From: Laura Gibbons
Sent: 15 March 2019 12:14
To: Planning.Responses
Cc: Simon Davis
Subject: RE: Planning Consultation on FP/42/19/DOC

Engineers Comments Regarding Condition 7

APPLICATION **FP/42/19/DOC**

Description of Works: Approval of details reserved by condition imposed under ref
FP/171/18/PL relating to Condition Nos
5,6,7,8,9,10,11,12,13,14 & 24.

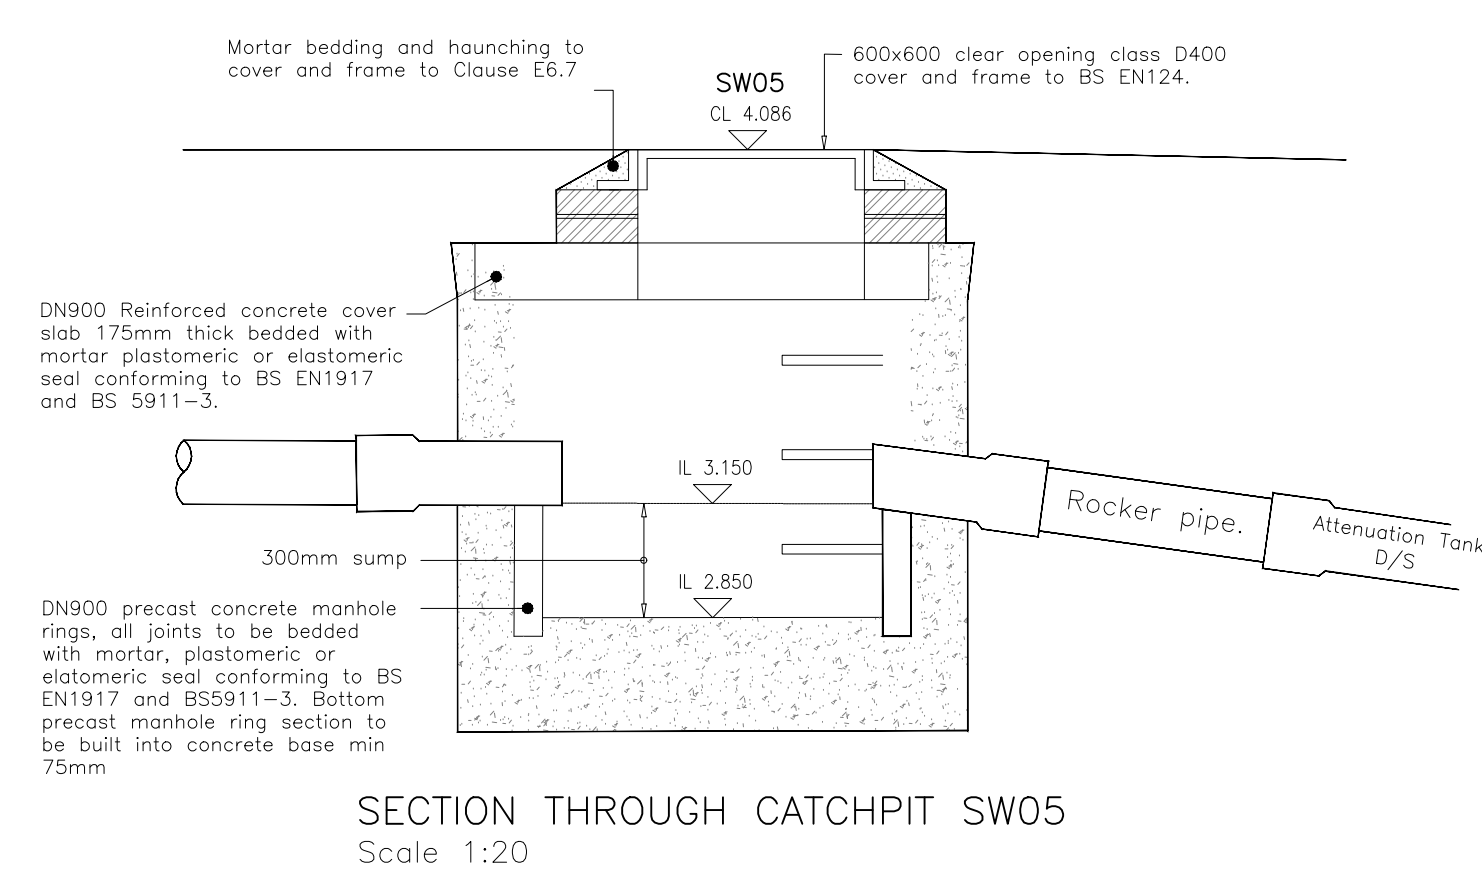
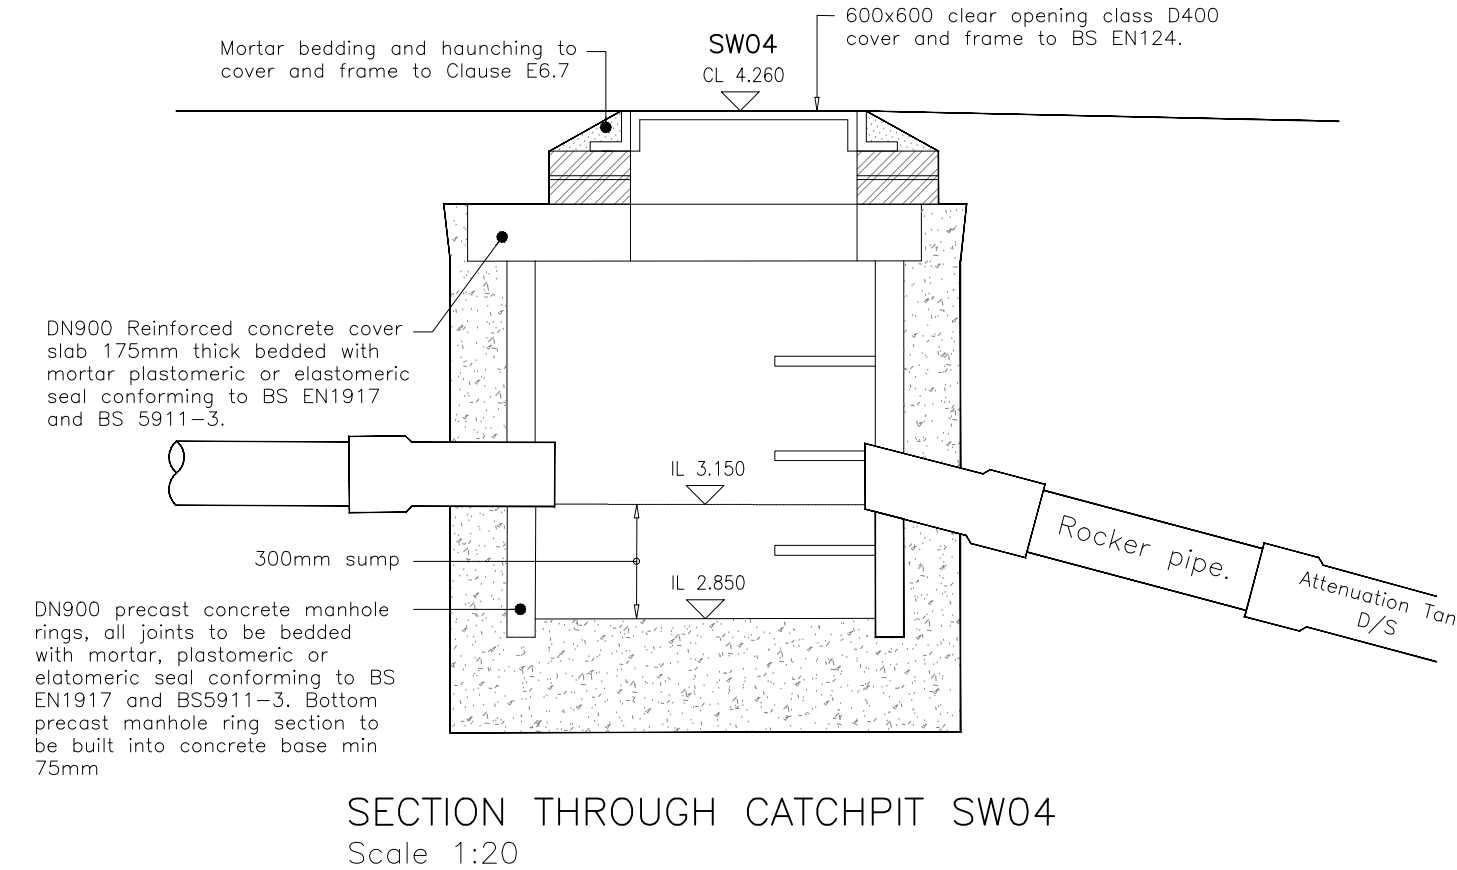
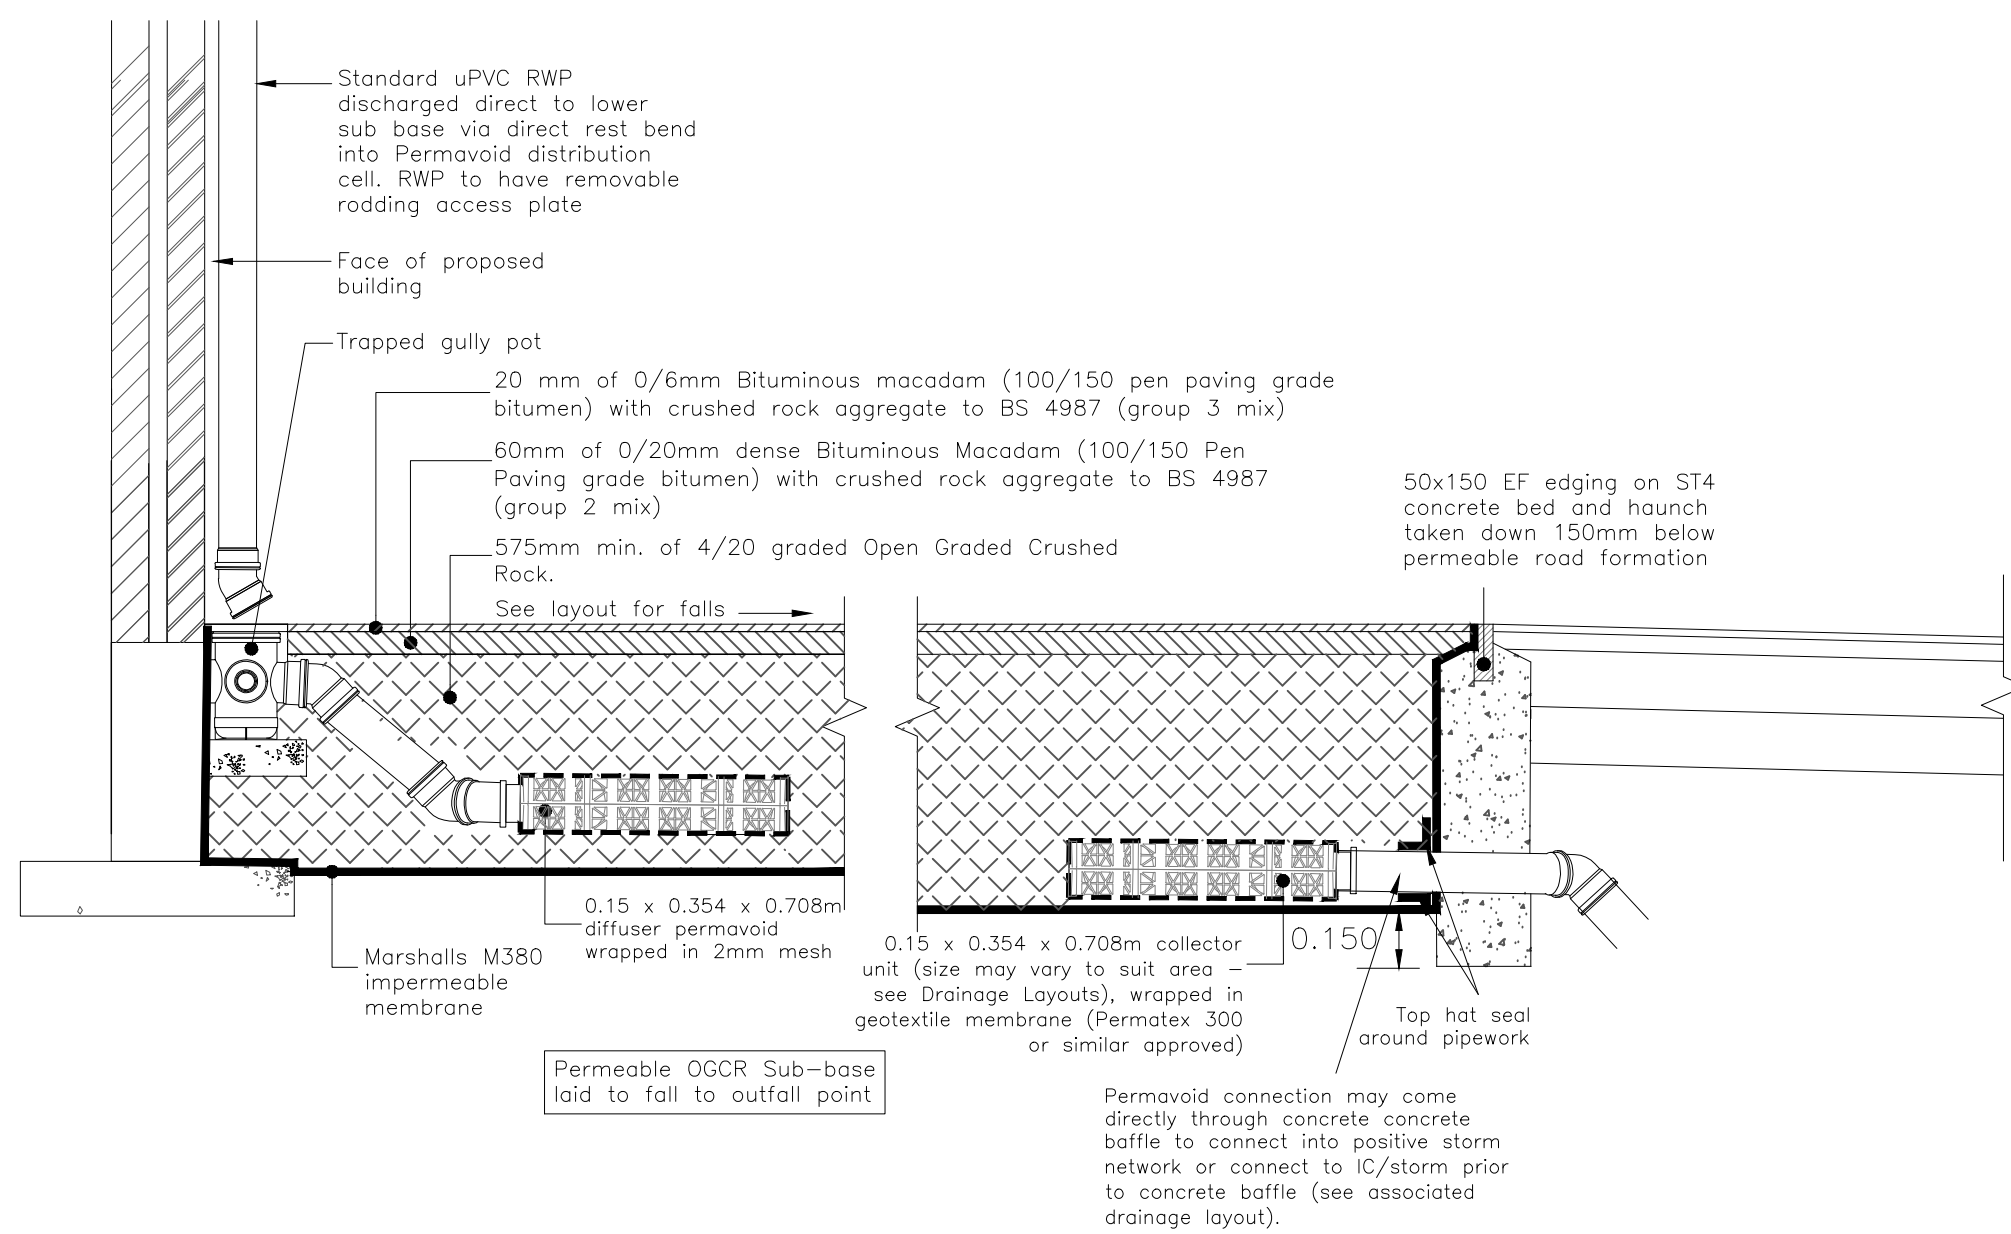
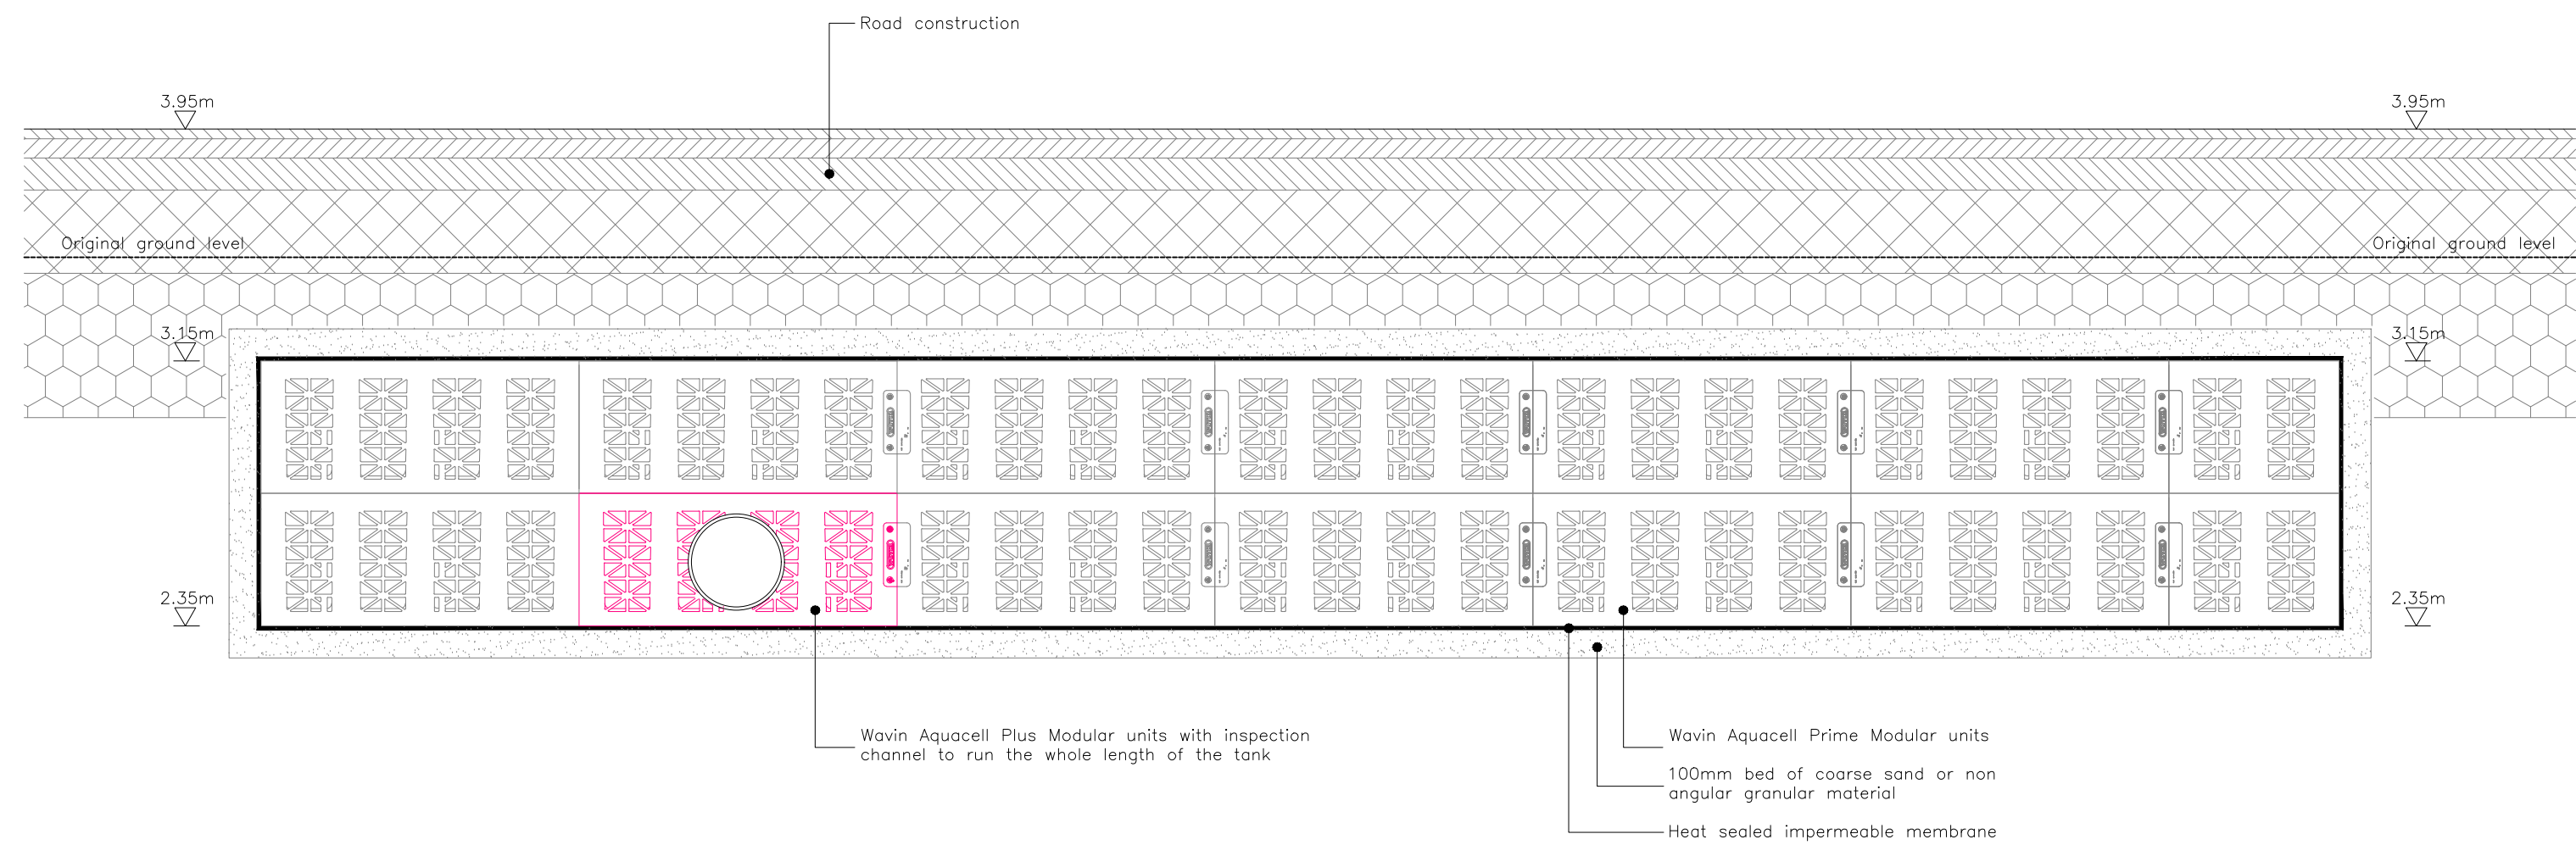
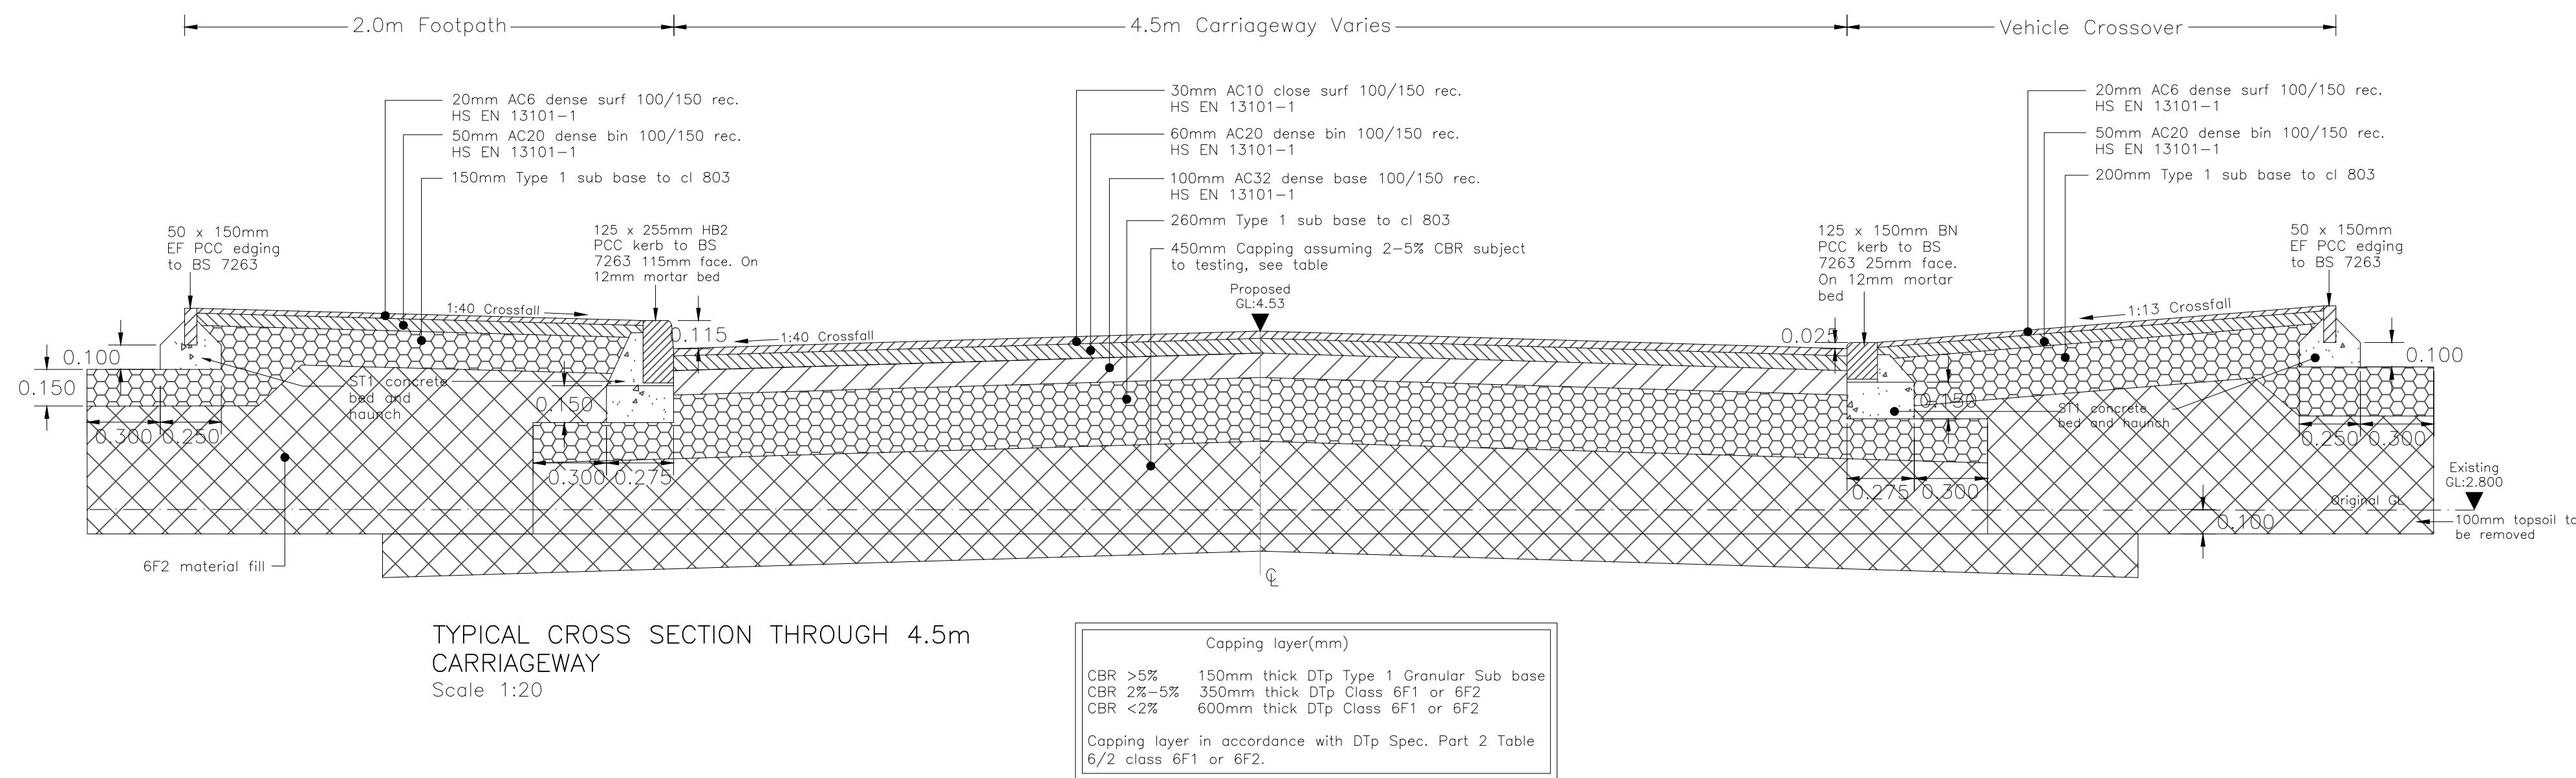
1. Catchpits must be provided upstream of all connections into the attenuation tank.
2. No construction detail drawings have been provided. Please provide construction detail drawings of manholes, catchpits, permeable paving, attenuation tank and hydrobrake.
3. There is conflict between the landscaping proposals and the drainage proposals. Trees must not be located on or near attenuation tanks. Please revise the landscaping proposals.
